## DEVELOPMENT REVIEW BOARD SUPPLEMENTAL SUBMITTAL

PROJECT NO. PR-2018-1580 (1005234)  
Application No. SI-2018-00153

**SUBMITTAL DESCRIPTION:** DRB resubmittal - Use Change from Hotel to Apartment

**HOTEL WYNDAM CHANGES - CHANGE OF USE**

SHEET #
LS-102

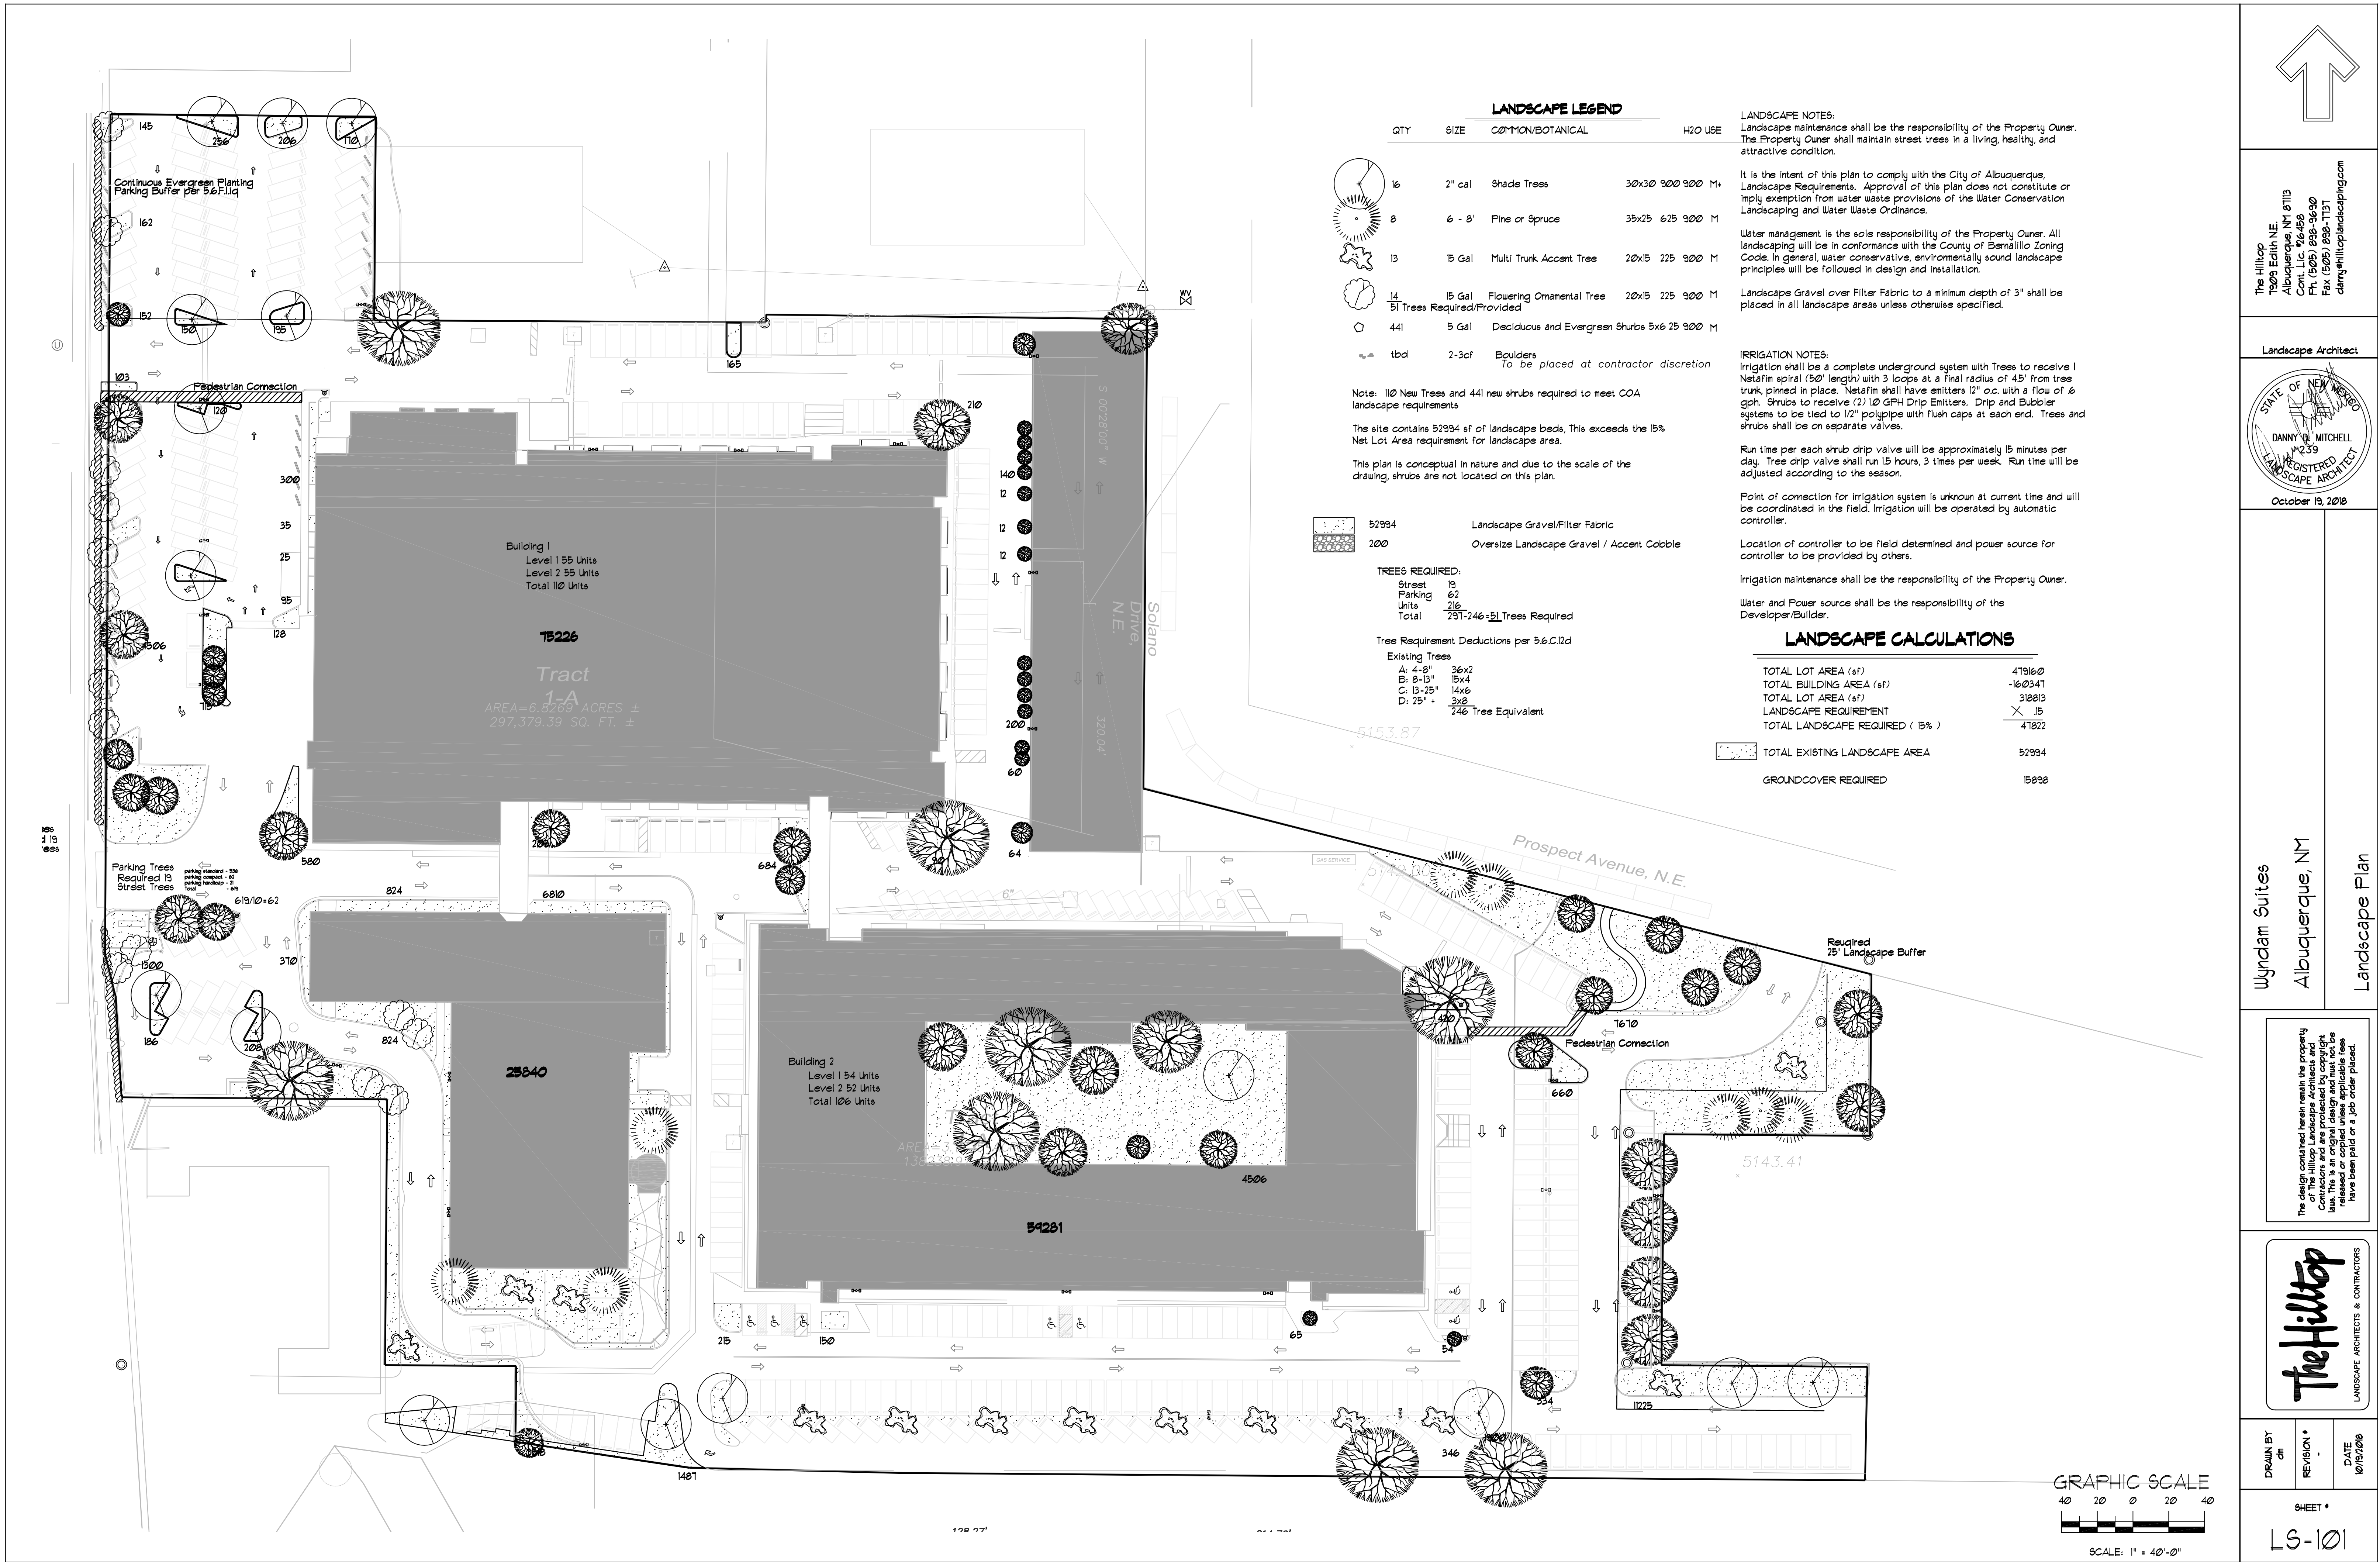
6. *Can the mature spread of plants be calculated on the plan to show how they meet the requirement that 75% of the total landscape area be covered by live materials? 25% of that coverage must be ground level – is this the groundcover number on the landscape plan? A better breakdown from total landscape requirement, 75% coverall amount, the*

*amount of plant coverage provided, what 25% of that coverage is, and then the total ground level provided would be helpful.*

7. *Please provide more specific species for the proposed plantings from the official plant list.*

9. *A street tree calculation is provided, but it appears that there are not enough trees within 20 feet of the back of curb to meet that number.*

10. *The landscape plan references the Bernalillo County zoning code. Please correct.*

11. *Between the existing landscape plan and proposed landscape plan, there is reference to providing 51 new trees for the conversion but also that 110 new trees are necessary (listed on both sheets), which causes some confusion. Please clarify.*

13. *There are two areas on the north sides of Buildings 1 and 2 that have parking spaces farther than 100 feet from a tree.*

**a. Landscape plan updated to include requested calculations.**

**a. Specific species information added to the Landscape Plan.**

**a. Additional trees have been indicated, however it is the professional opinion of the Landscape Architect that trees planted in this area are subject to premature death due to the nature of the environment. Even with drought tolerant species their long-term success is in question.**

**a. Corrected.**

**a. Tree count references have been coordinated and corrected.**

**a. These omissions have been corrected on the Landscaping plan.**
